Durham County Council

Application for removal or variation of a condition following grant of planning permission. Town and Country Planning Act 1990. Planning (Listed Buildings and Conservation Areas) Act 1990

4. Description of the Proposal

Residential development of 96 dwellings (inc. bungalows) with access, open space, SUDs and landscaping. Provision of dedicated parking spaces and acoustic boundary fence to boundary of the existing vehicle maintenance workshops.

Site Layout

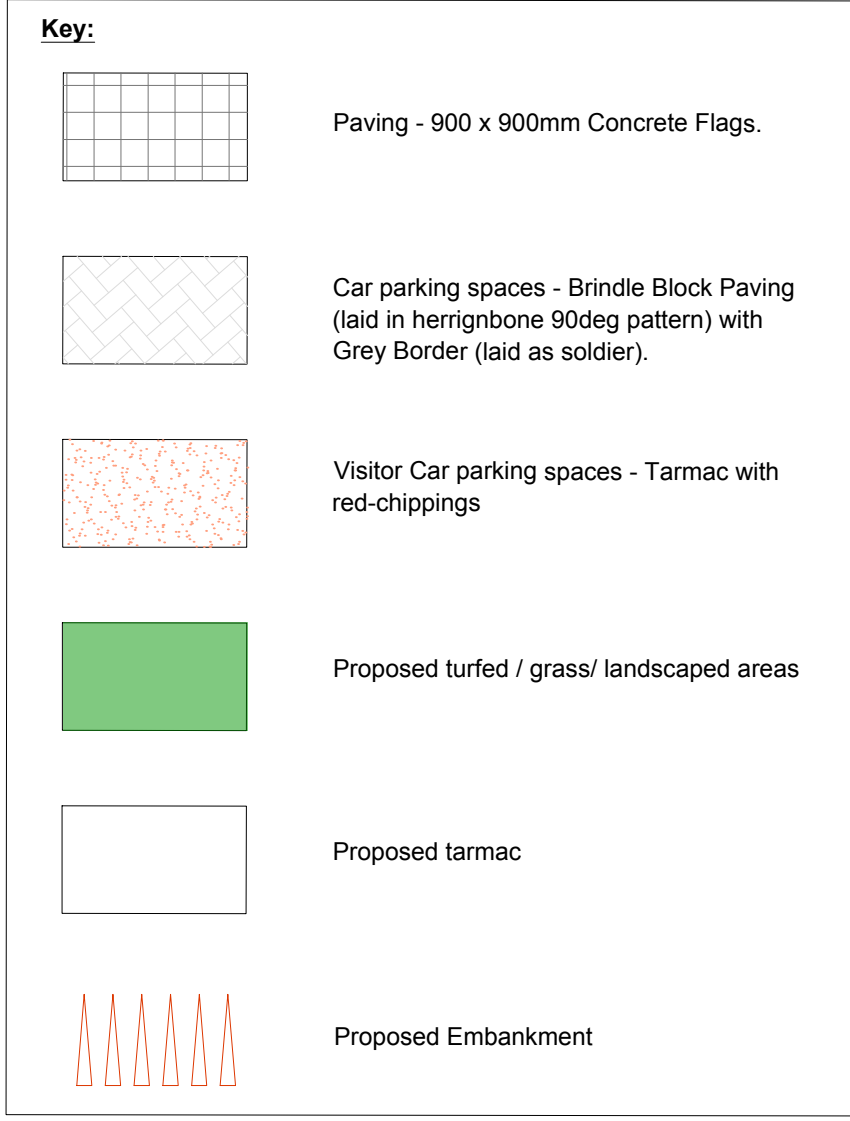
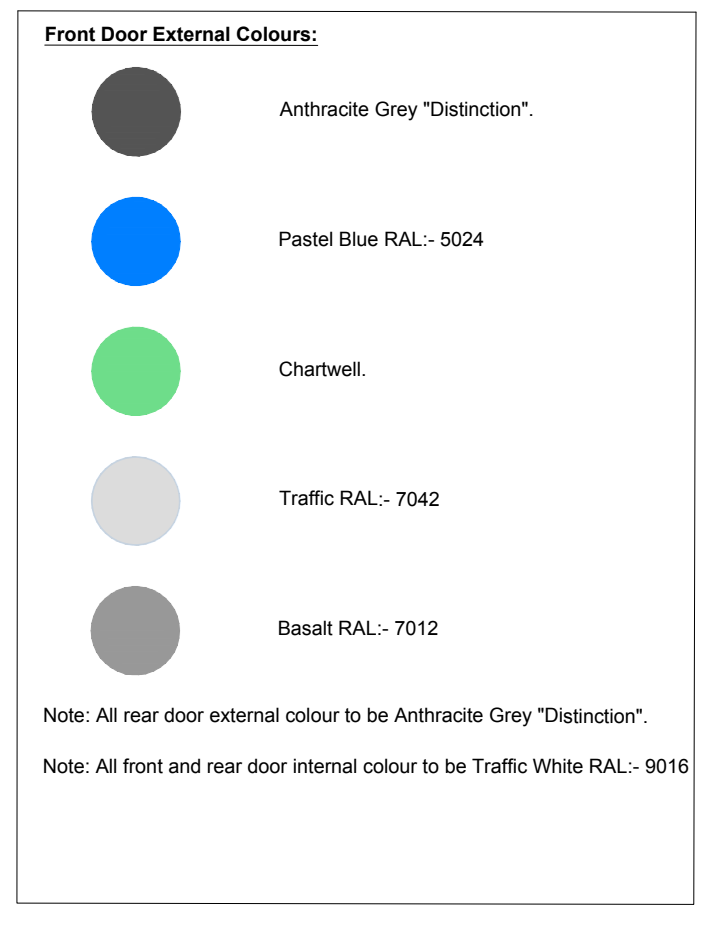
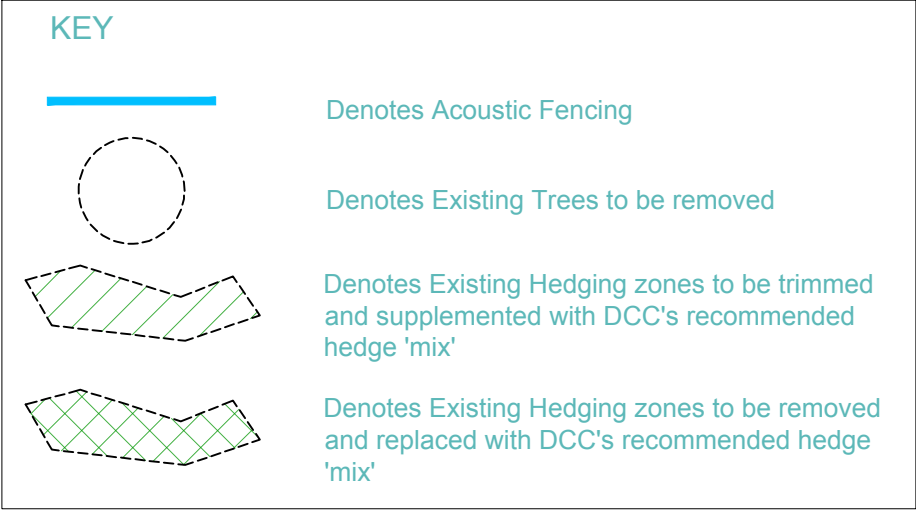
Approved site layout drawing number 2826.06.022X indicated existing groups of trees identified as "G4" on the Arboricultural Assessment Plan being retained along the western boundary between plots 31-42. The root zone prevents the construction of the retaining walls and surface water bunding along the rear garden boundary.

Approved site layout drawing number 2826.06.022X to be updated and substituted with drawing number 2826.06.022Zd.
